ENG-SF18027-2024R1 - FDR.pdf Markup Summary

In the Filing 3 drainage report OS-4 which corresponds with DP-6 is listed as having flows of 2 and 6 cfs. Discuss discrepancies between original calculations and proposed results and verify the rain garden can still accept all flows from filing 4.

RETREAT AT TIMBERIDGE FILING NO. 4			
CONSTRUCTION PLANS			
DETENTION FACILITY POND 4			
POND PLAN			
DESIGNED BY	MAW	SCALE	DATE 1-15-24
DRAWN BY	MAW	(H) 1" = 30'	SHEET 12 OF 14
CHECKED BY	(V) 1" = N/A	JOB NO.	1185.31

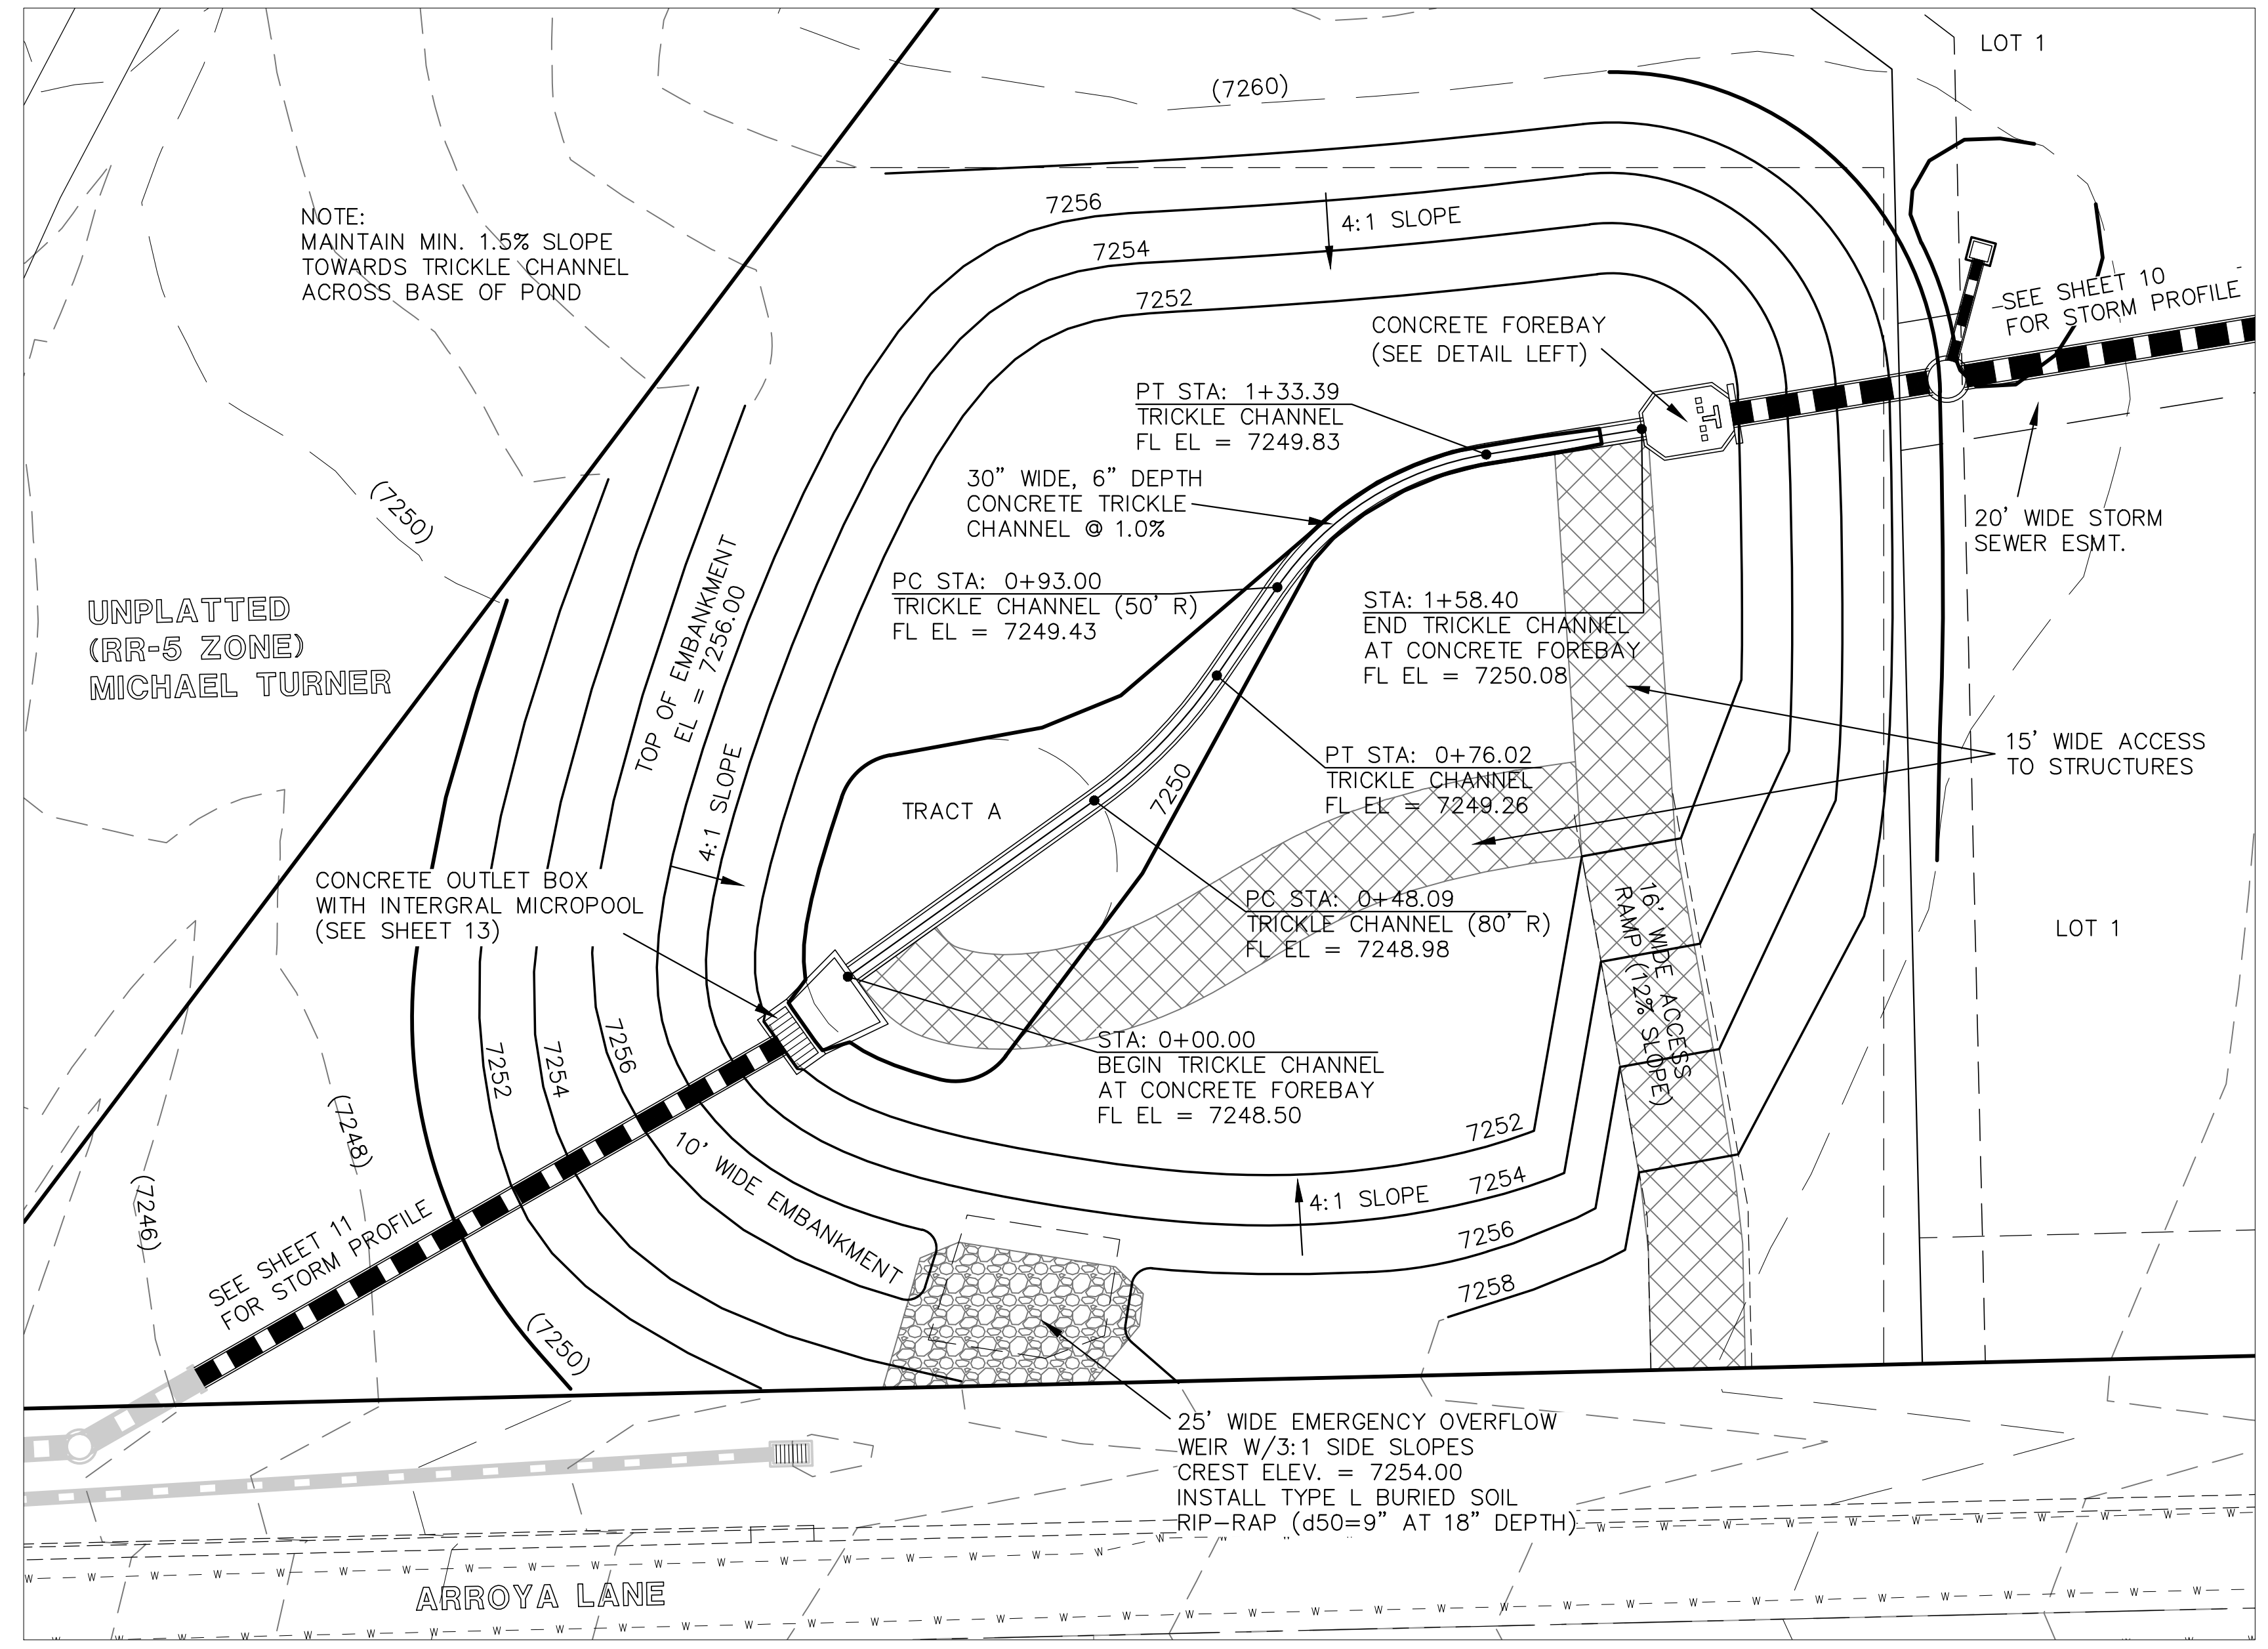
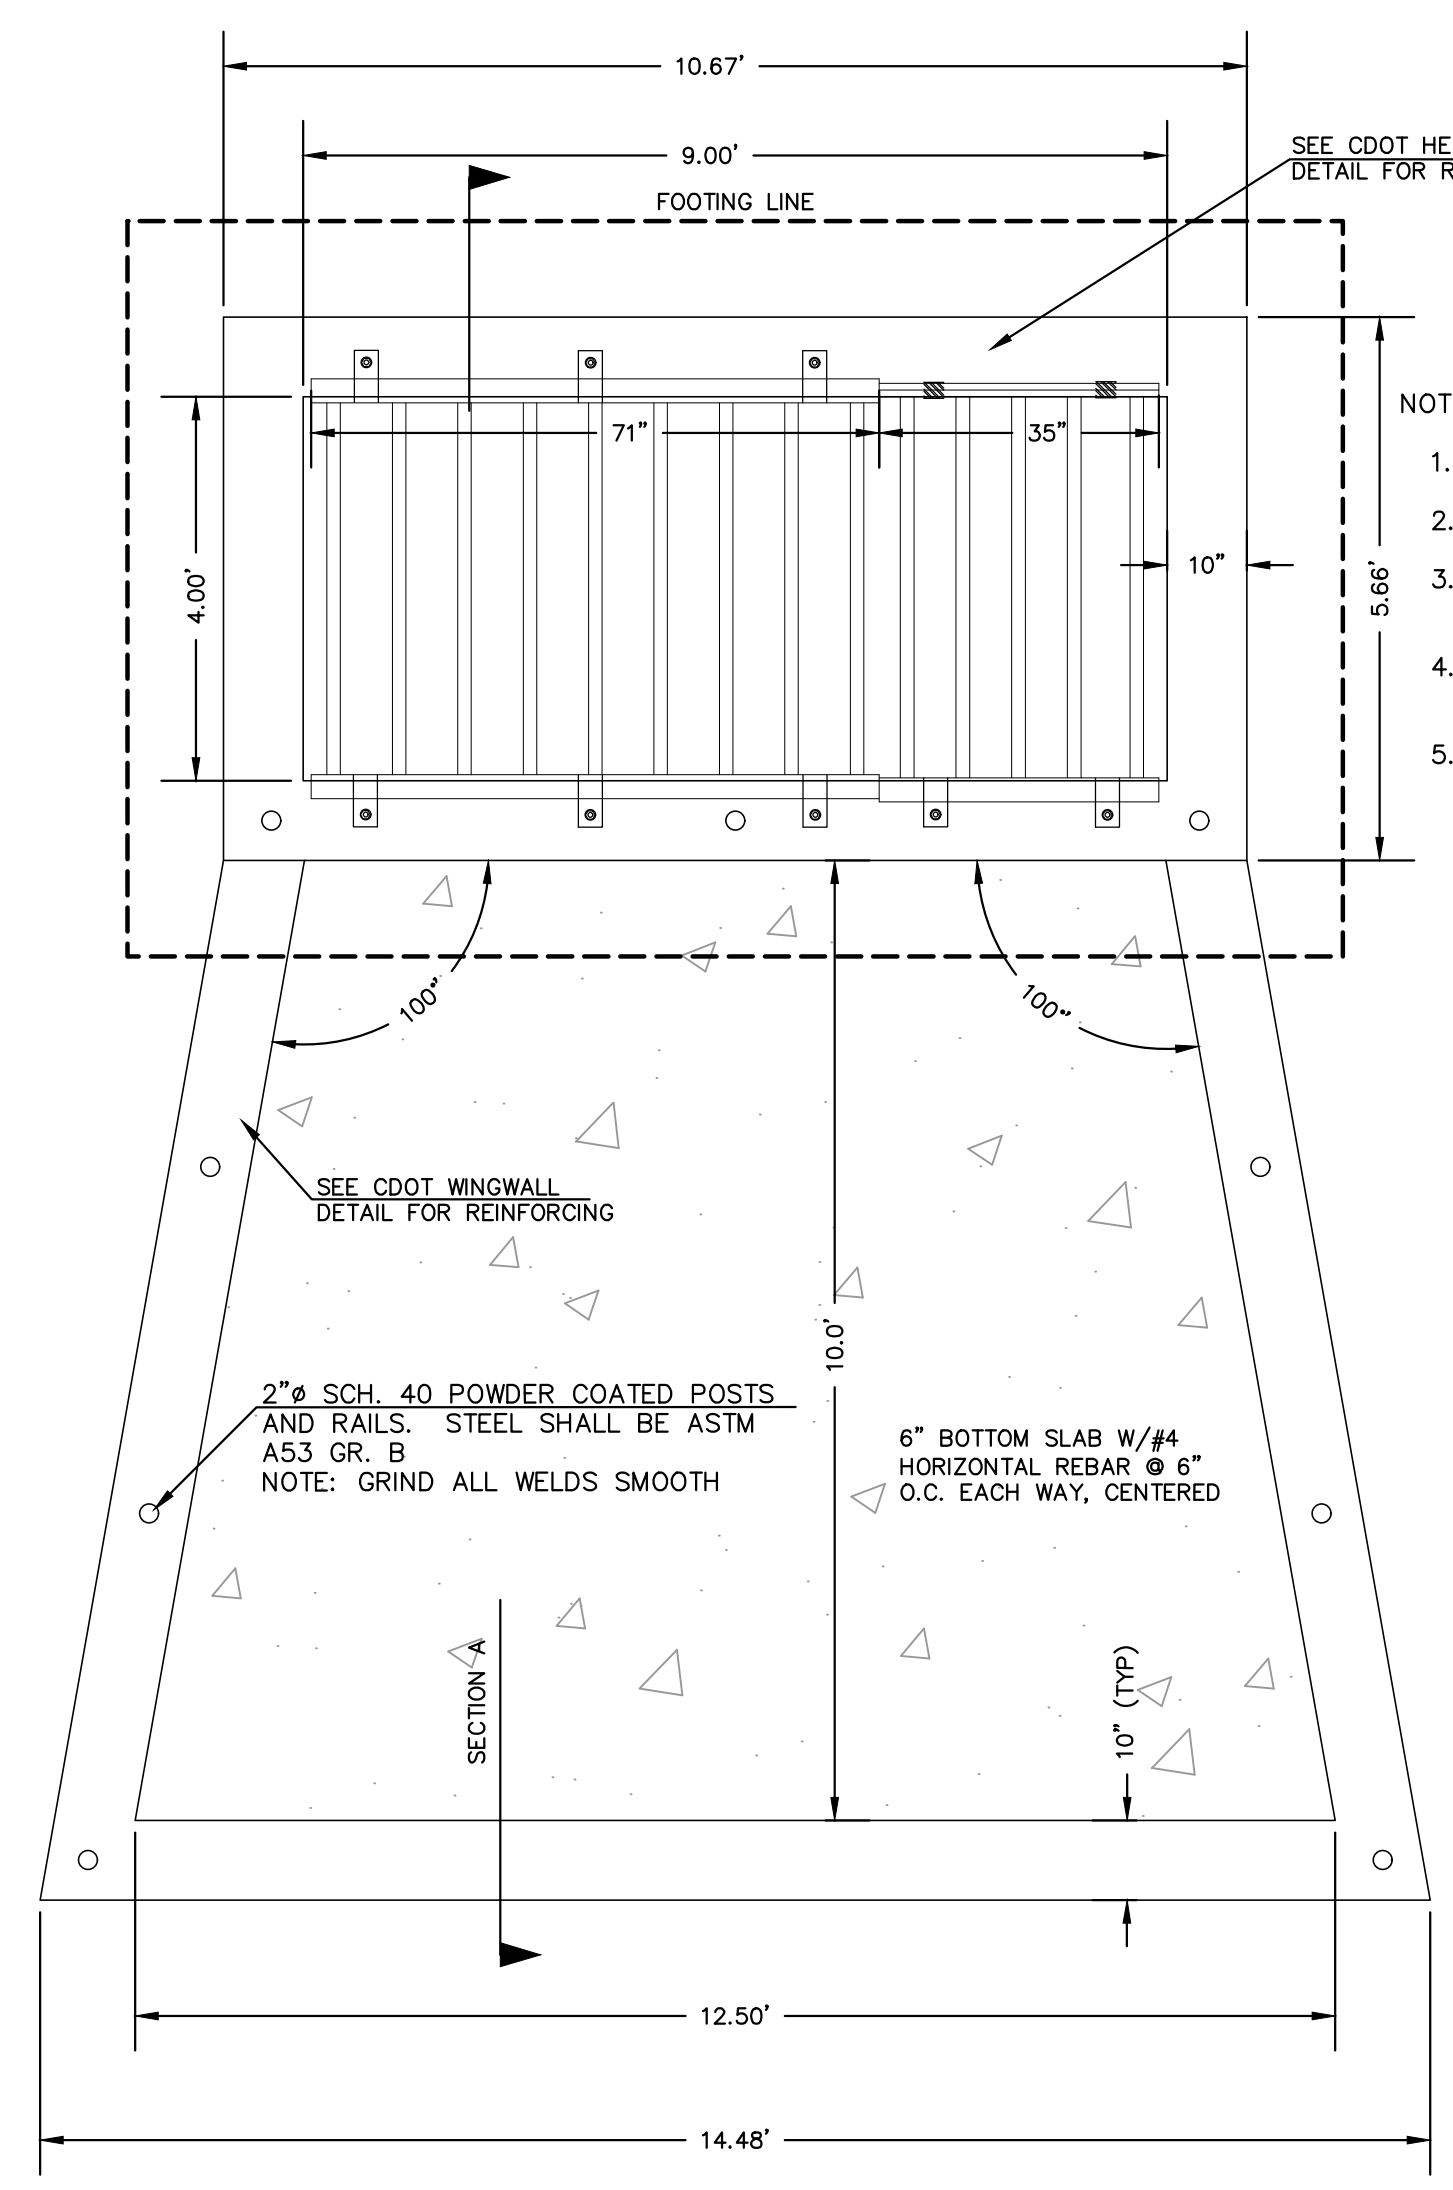
Per DCMv2 – Chap 4.2, trickle channel should at a minimum provide capacity equal to twice the release capacity at the upstream forebay outlet. Provide these calcs in the drainage report and revise plans as needed.

Pond 4?
